EL PASO COUNTY PLANNING AND COMMUNITY DEVELOPMENT DEPARTMENT

GRADING AND EROSION CONTROL PLAN CHECKLIST

Revised: July 2019

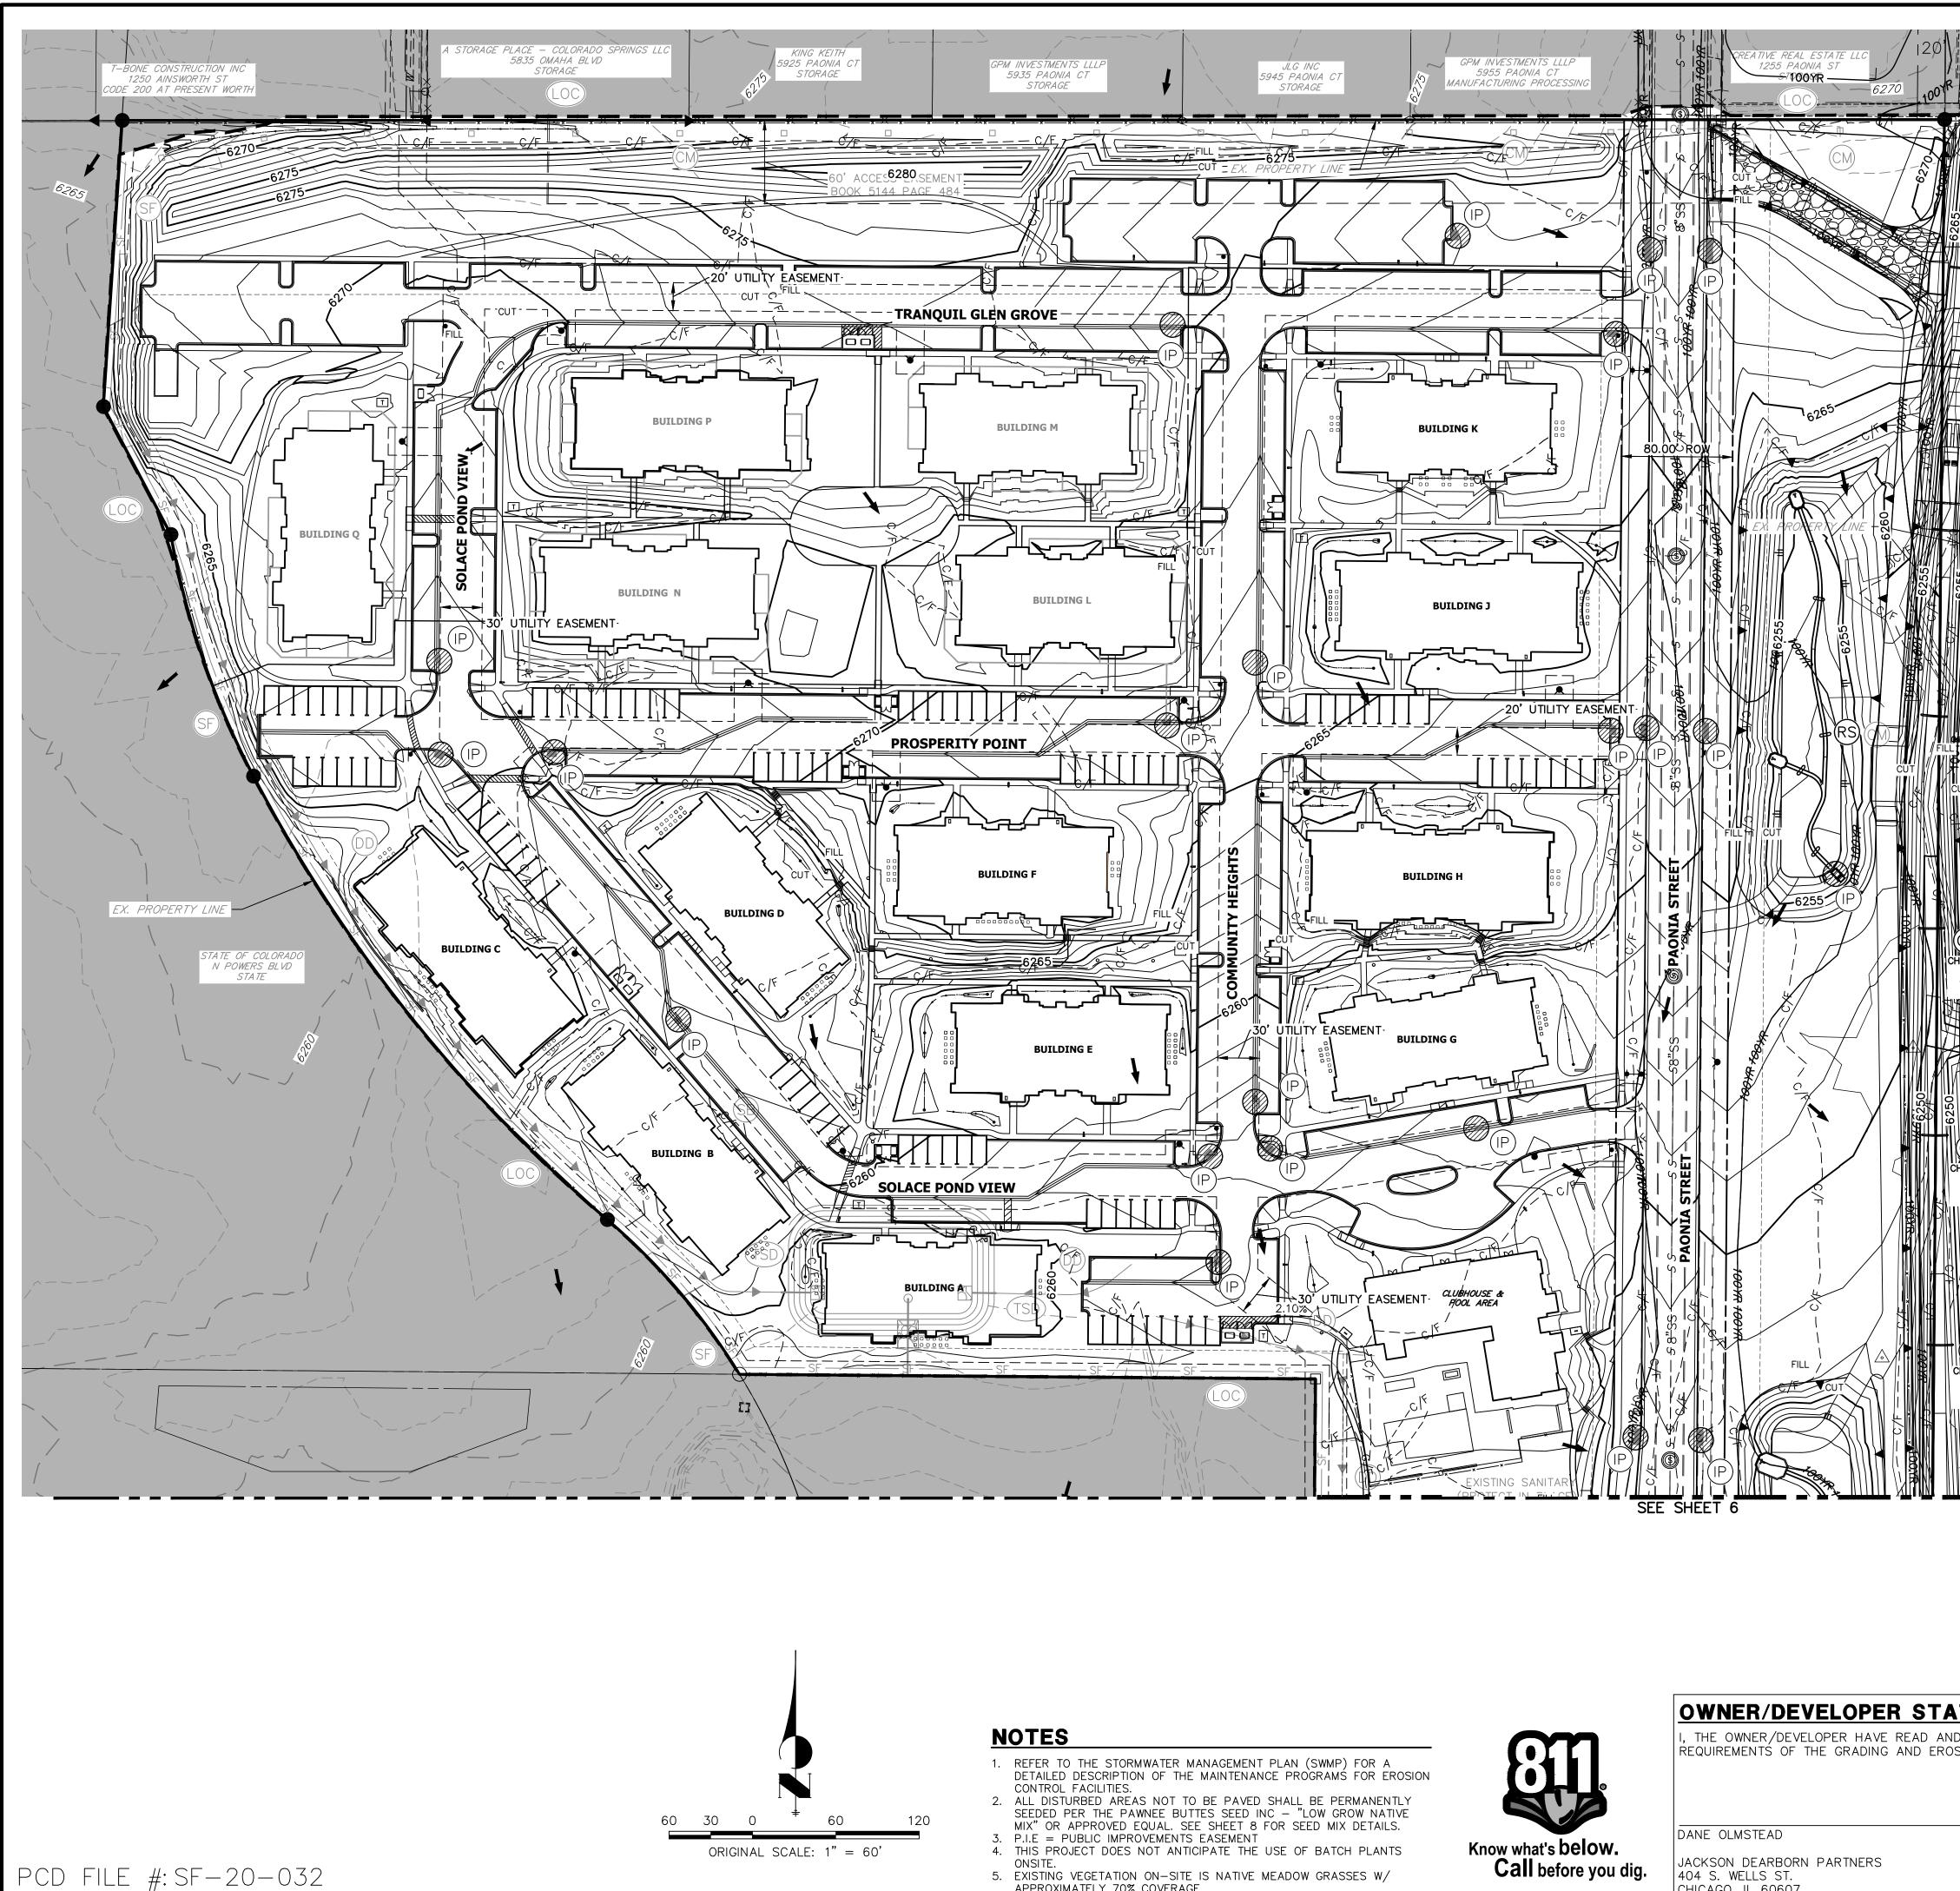
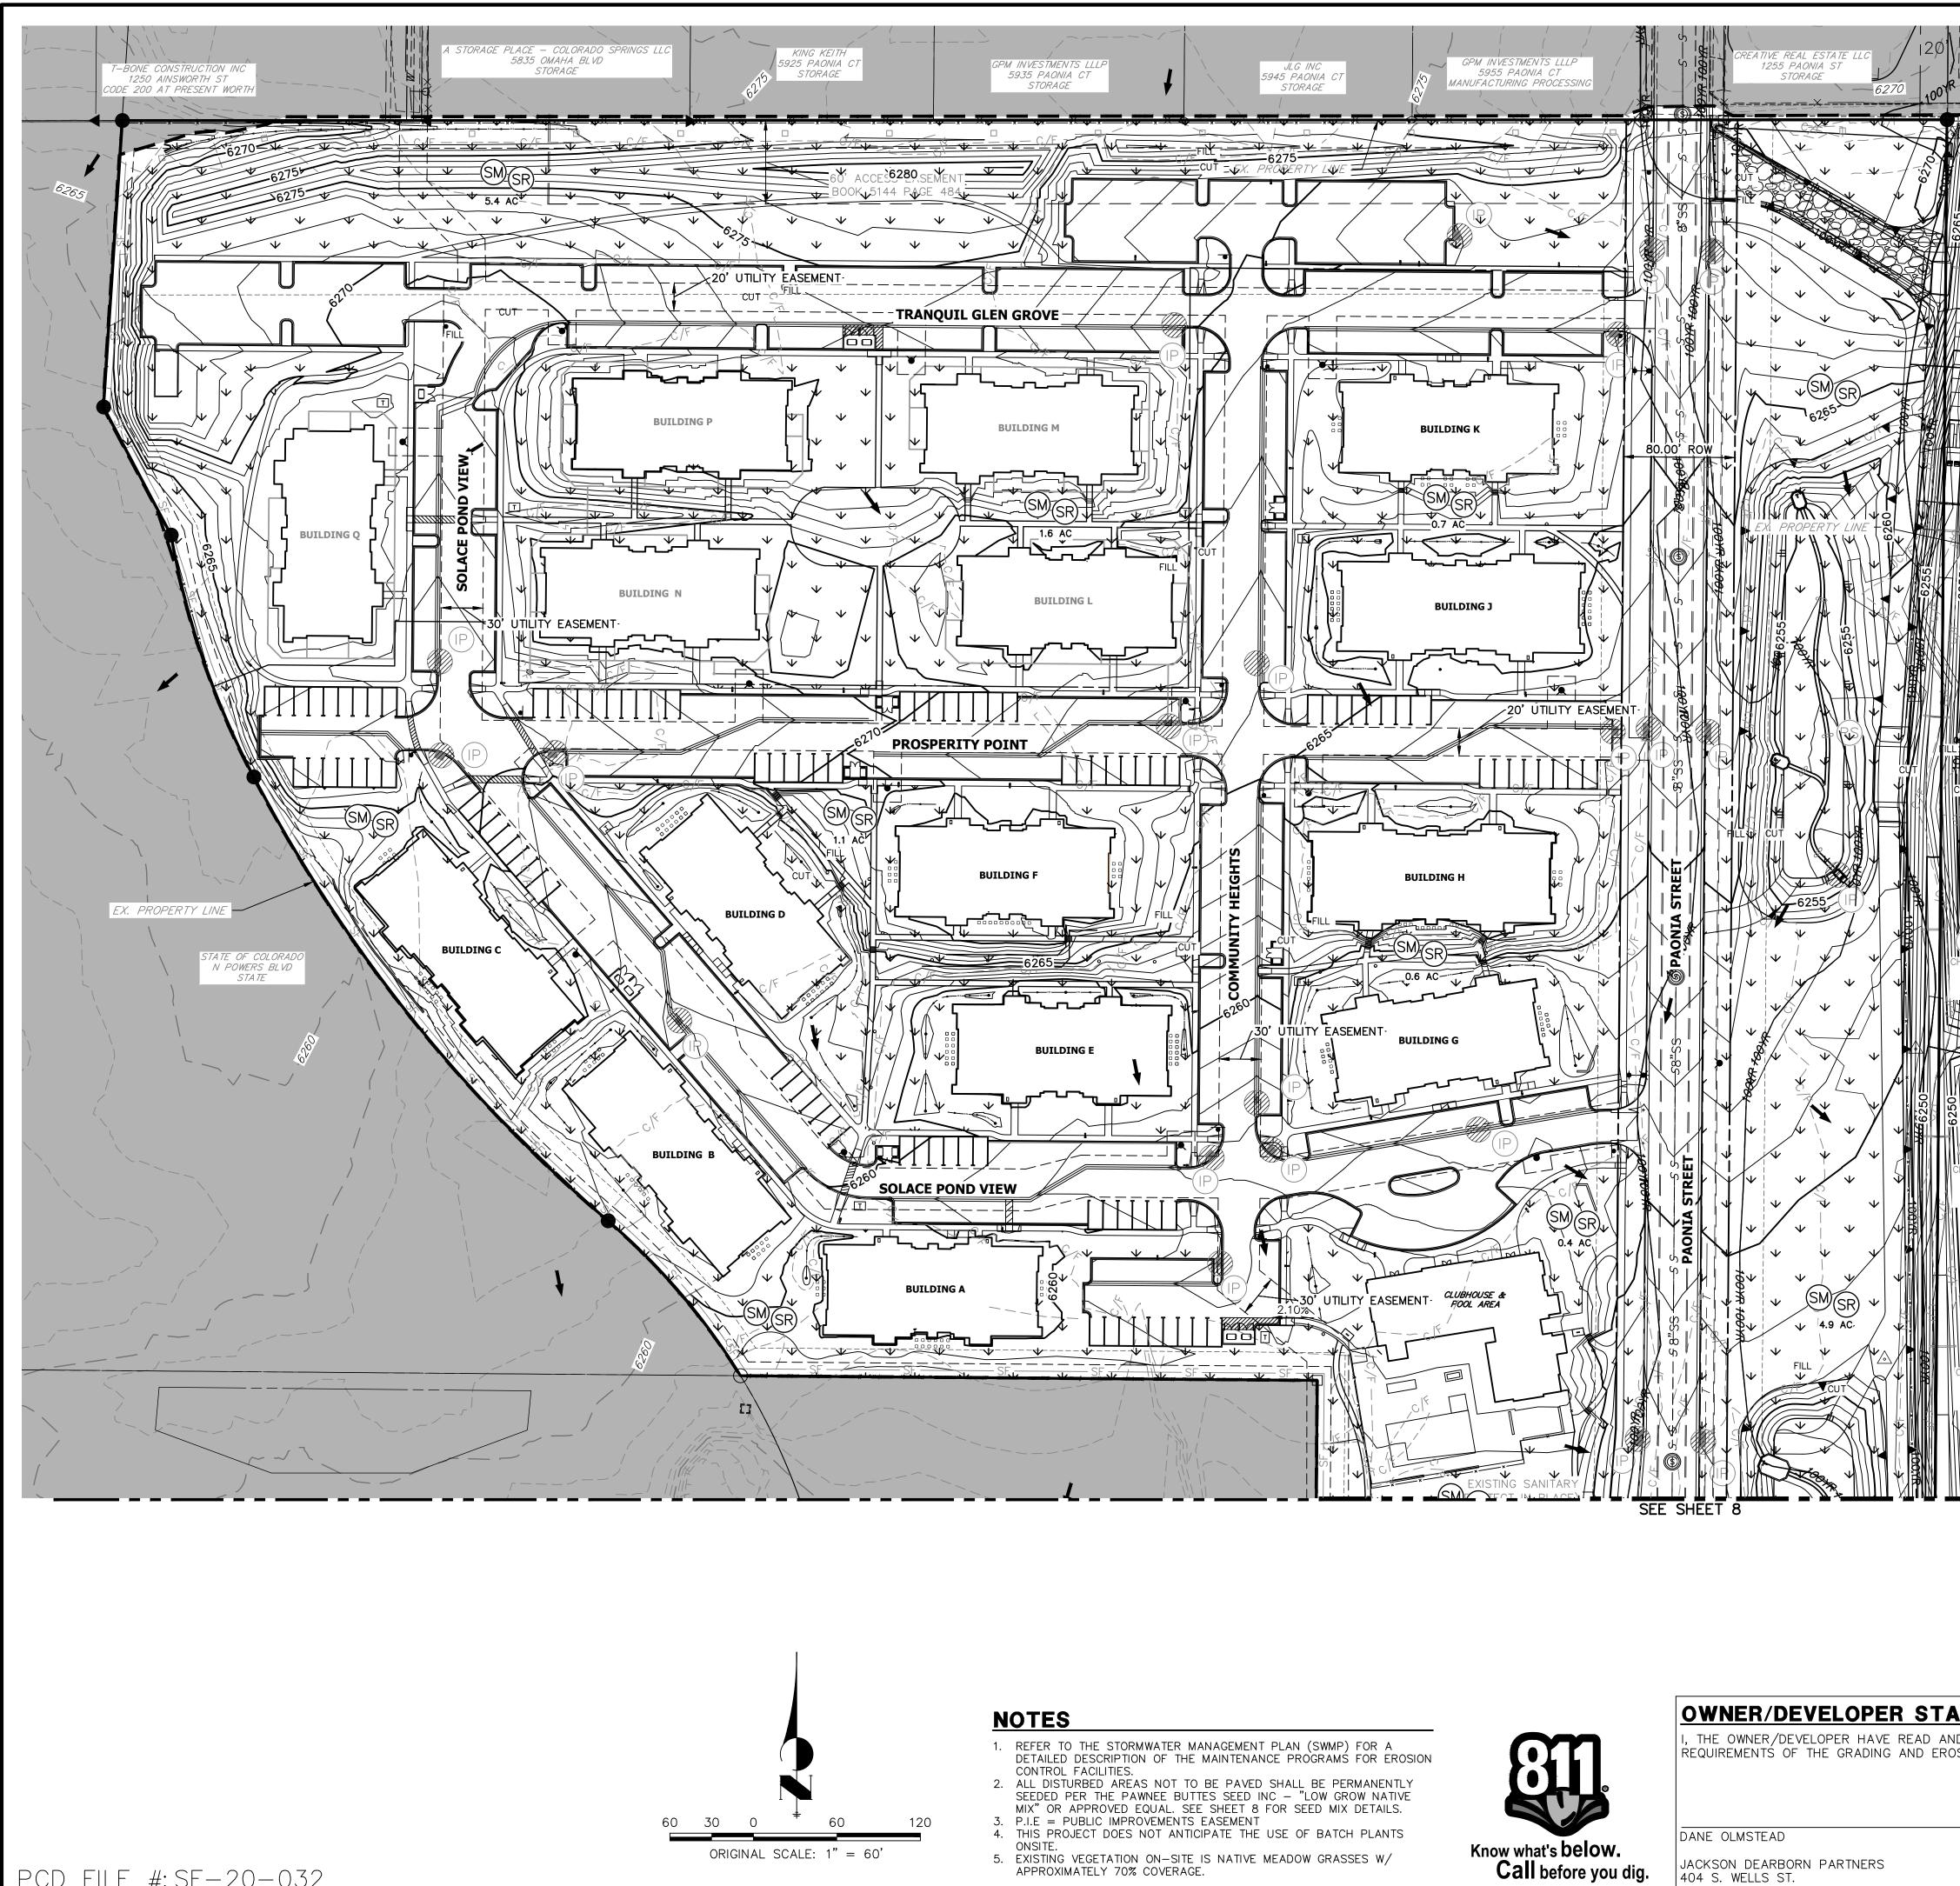
| | | Applicant | PCD |
|--|---|-----------|-----|
| i | Existing vegetation (notes are acceptable in cases where there is no notable vegetation, only grasses/weeds, or site has already been stripped). | ✓ | ✗ |
